ENG-EGP22006-R1-GEC.pdf Markup Summary

Subject: Stormwater Comments Color
Page Index: 1
Date: 3/14/2023 4:42:40 PM
Author: dotprete
Color: ■
Layer:
Space:
Page Label: [1] 1 2514207CV02 - CV01

Table VT-1

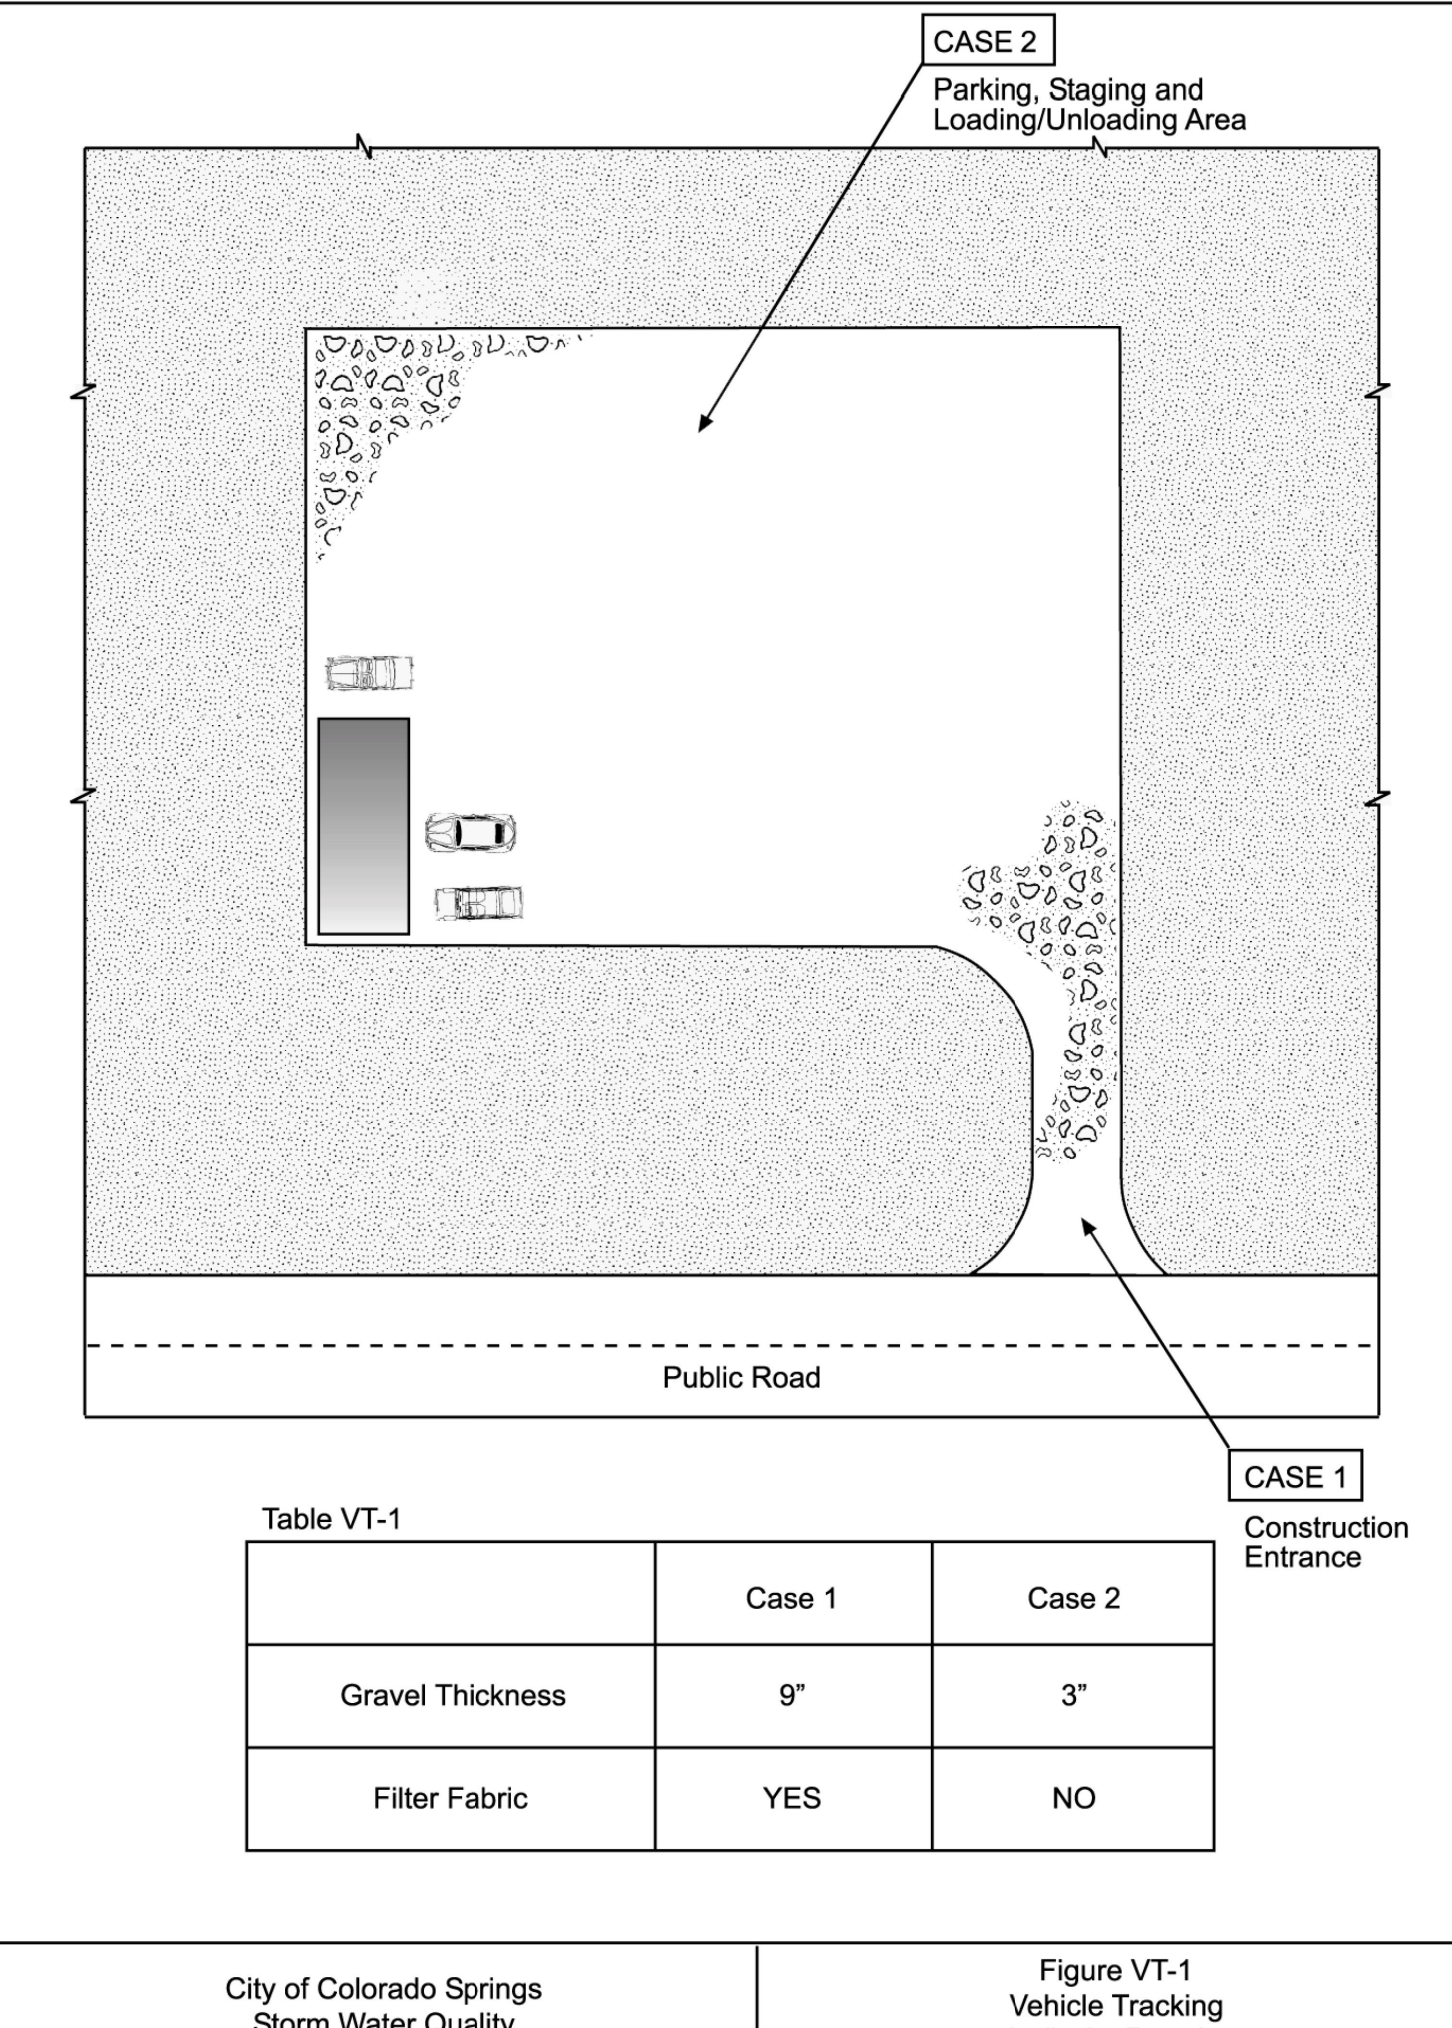
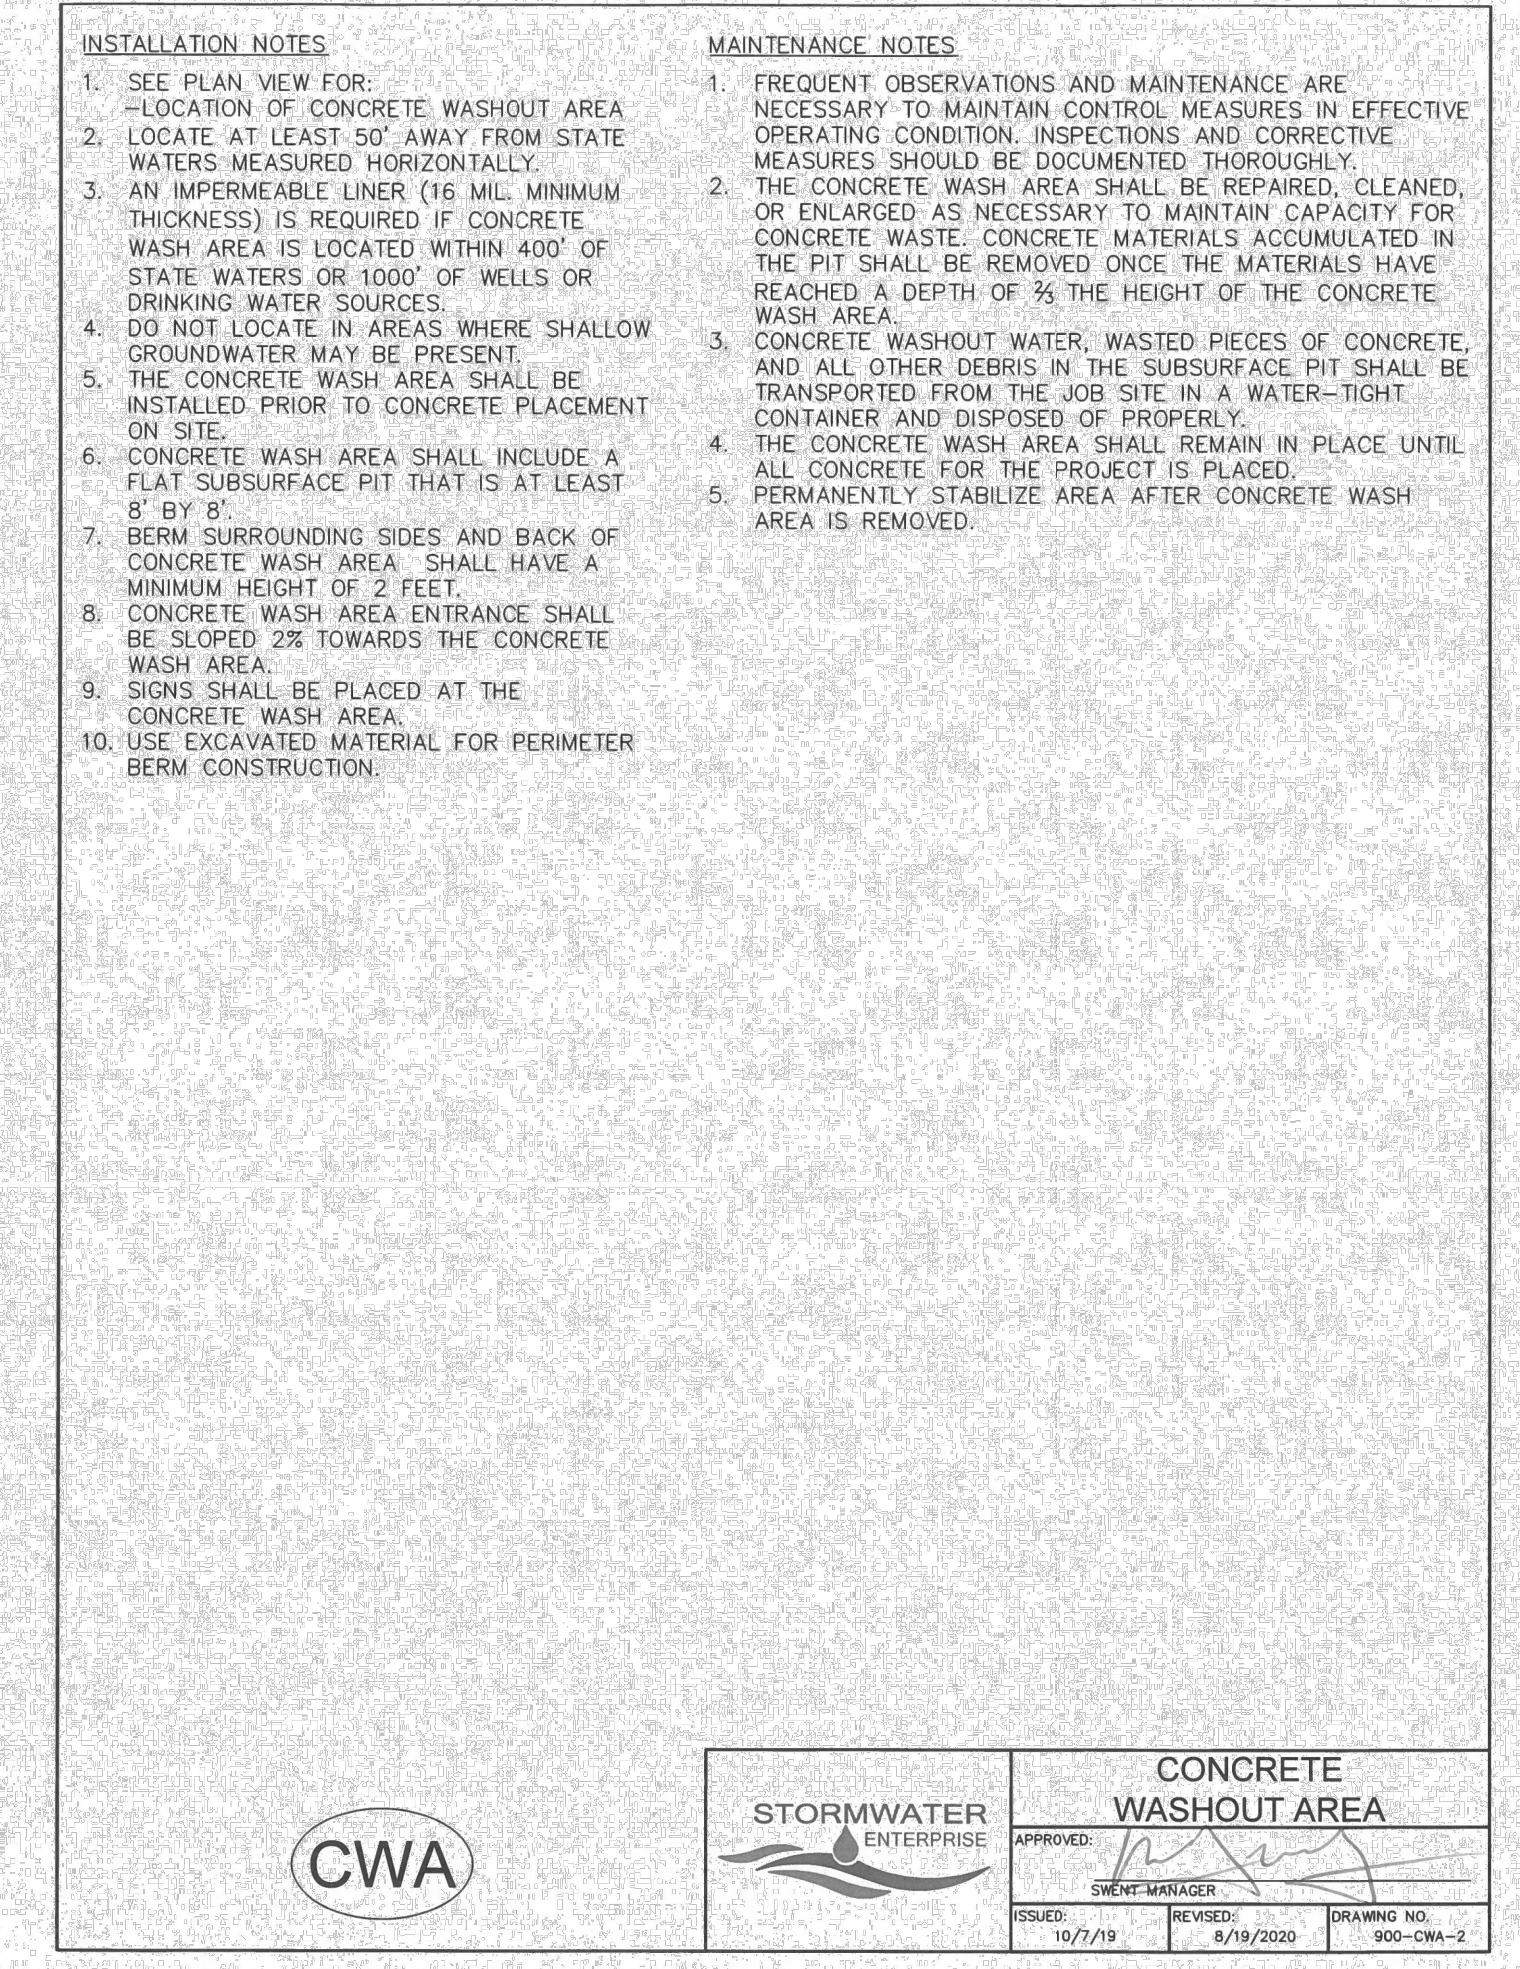
Replace with EPC approved VTC detail (VT-1 and VT-2 in DCMv2, Chap 3.3) or revise to be 75ft min length.
